REVERB ACOUSTICS

Our Ref: 08-1223-L3

2 March 2022

REQUEST FOR ADDITIONAL INFORMATION (ACOUSTICS) THE PINES PARK MODIFICATION – 8 HEARNES ROAD, WOOLGOOLGA

DRAWING NUMBER  
**MP01**

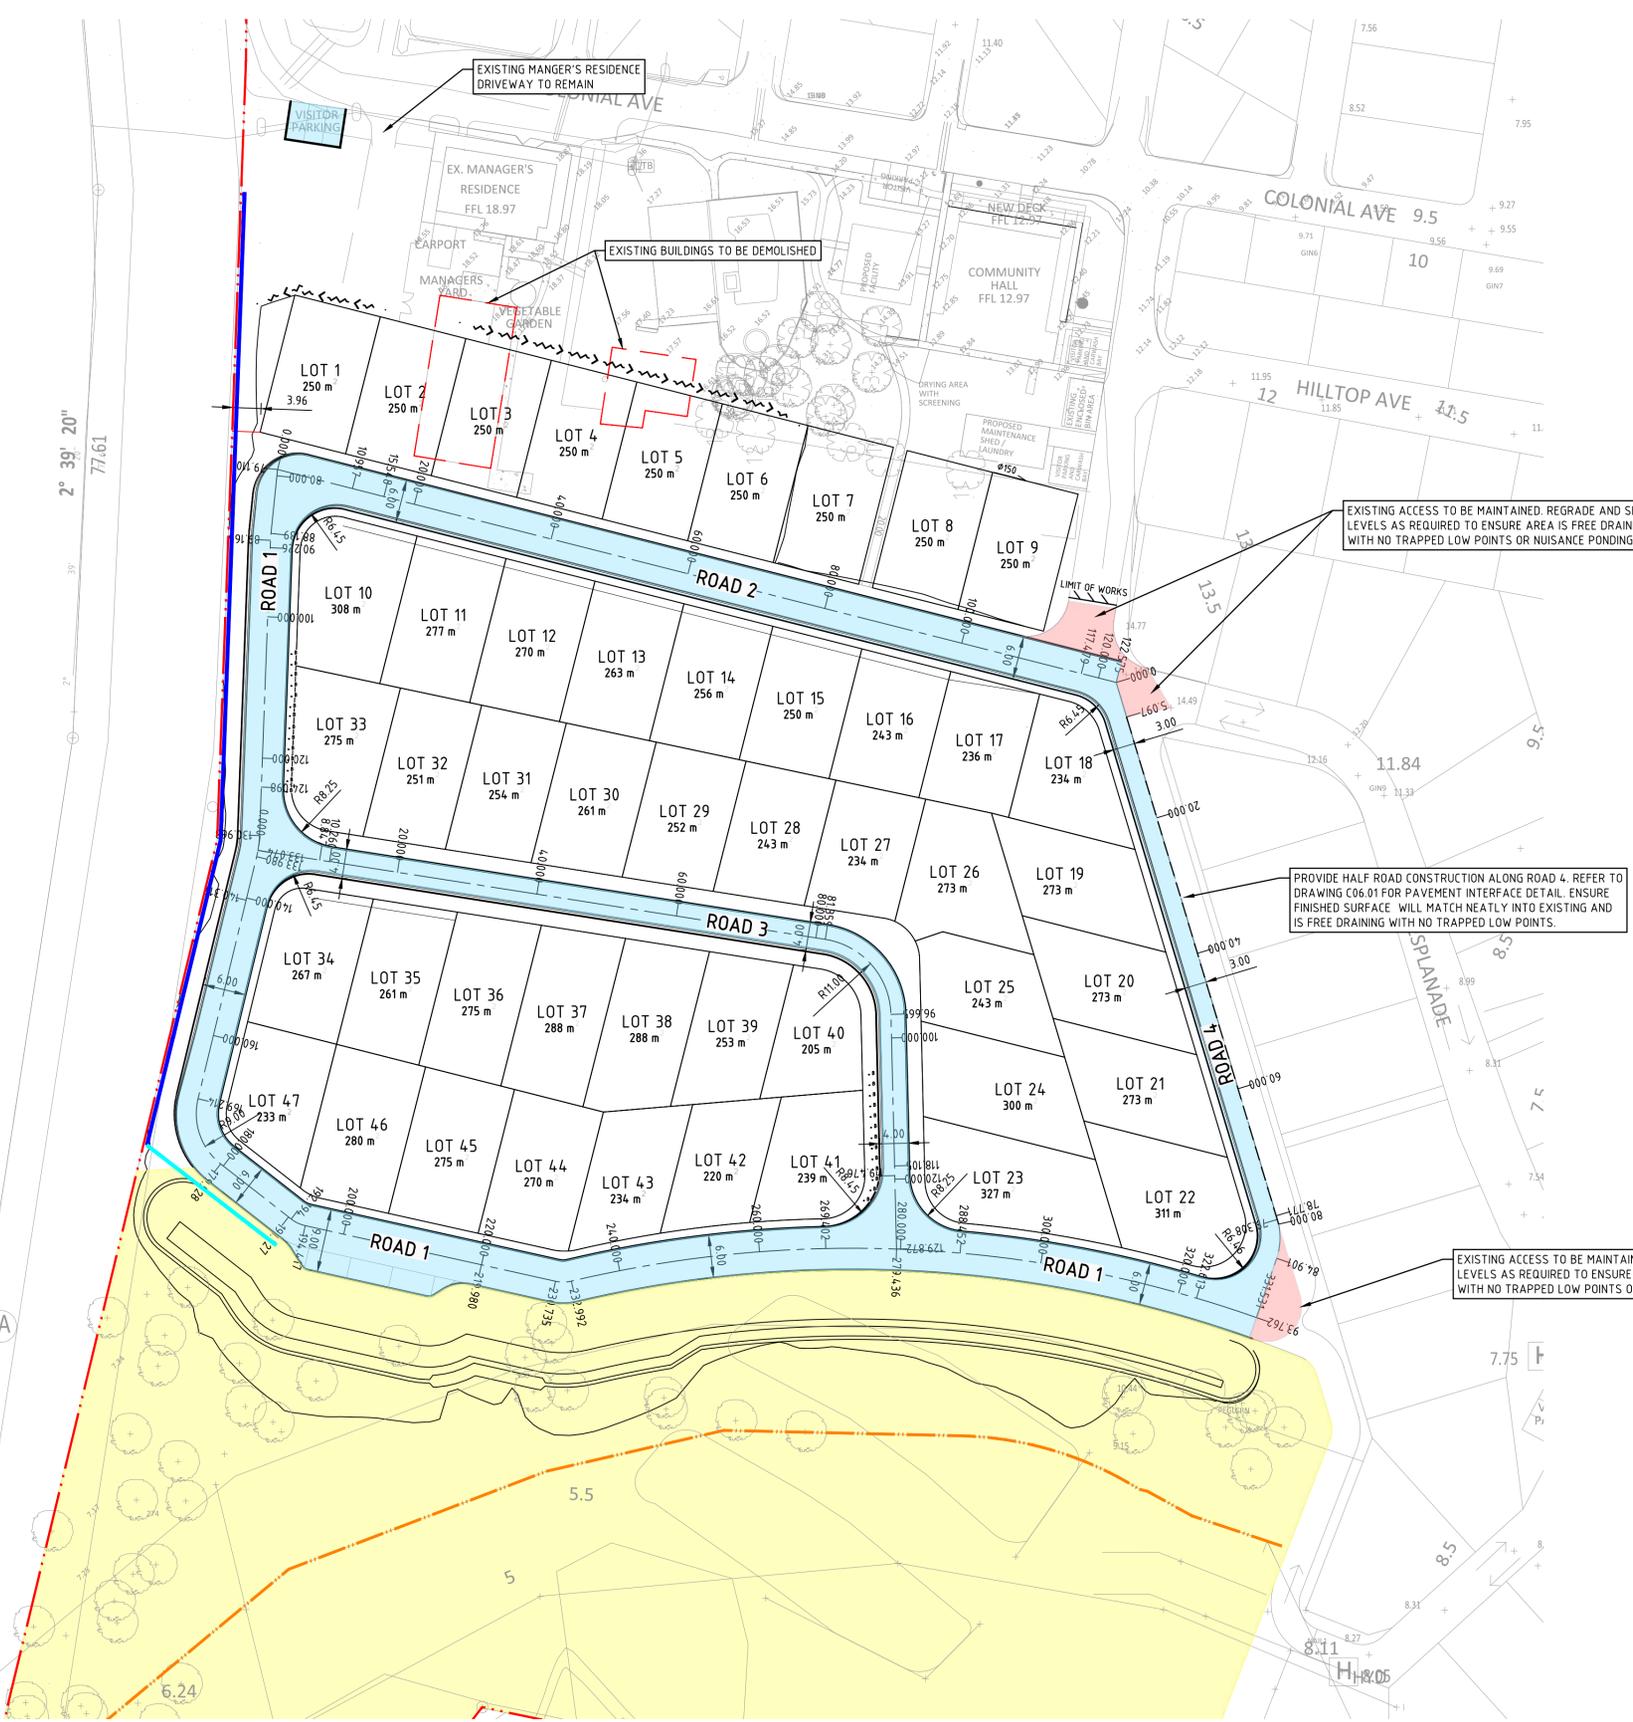
DPE REQUEST: *It has been identified upon the review of documentation that the plans submitted with MP08_0005-Mod-2 have not included a previously approved acoustic fence along the western and part of the southern boundaries. It is also noted that site 1 is in closer proximity to what was previously assessed under the acoustic assessment submitted with MP08_0005 (prepared by Reverb Acoustics, September 2009). It is requested that an addendum to this report be prepared to outline the suitability of site 1 with respect to the traffic noise.*

Section 6 of the provides acoustic recommendations to ensure noise levels within future dwellings achieve the requirements of C38, i.e. walls roof, ventilation, etc. Acoustic fences have also been recommended as follows (also see attached Masterplan):

Location	Height above FGL (mm)
West Boundary	2400
South Boundary (PART)	1800

The acoustic fence extends north along the west boundary sufficient distance to provide equivalent attenuation of road traffic noise for Lot 1, afforded to other Lots further south.

Lot 1 is equivalent in location in relation to the Pacific Highway as previous Lot 7 (see RA-R2 report) and current Lot 10 (see attached Masterplan). Therefore providing equivalent noise control modifications are incorporated into the design, compliance will be achieved. For reference, part of Table 4, taken from the RA-R2 is reproduced below, which applies to Lot 1:
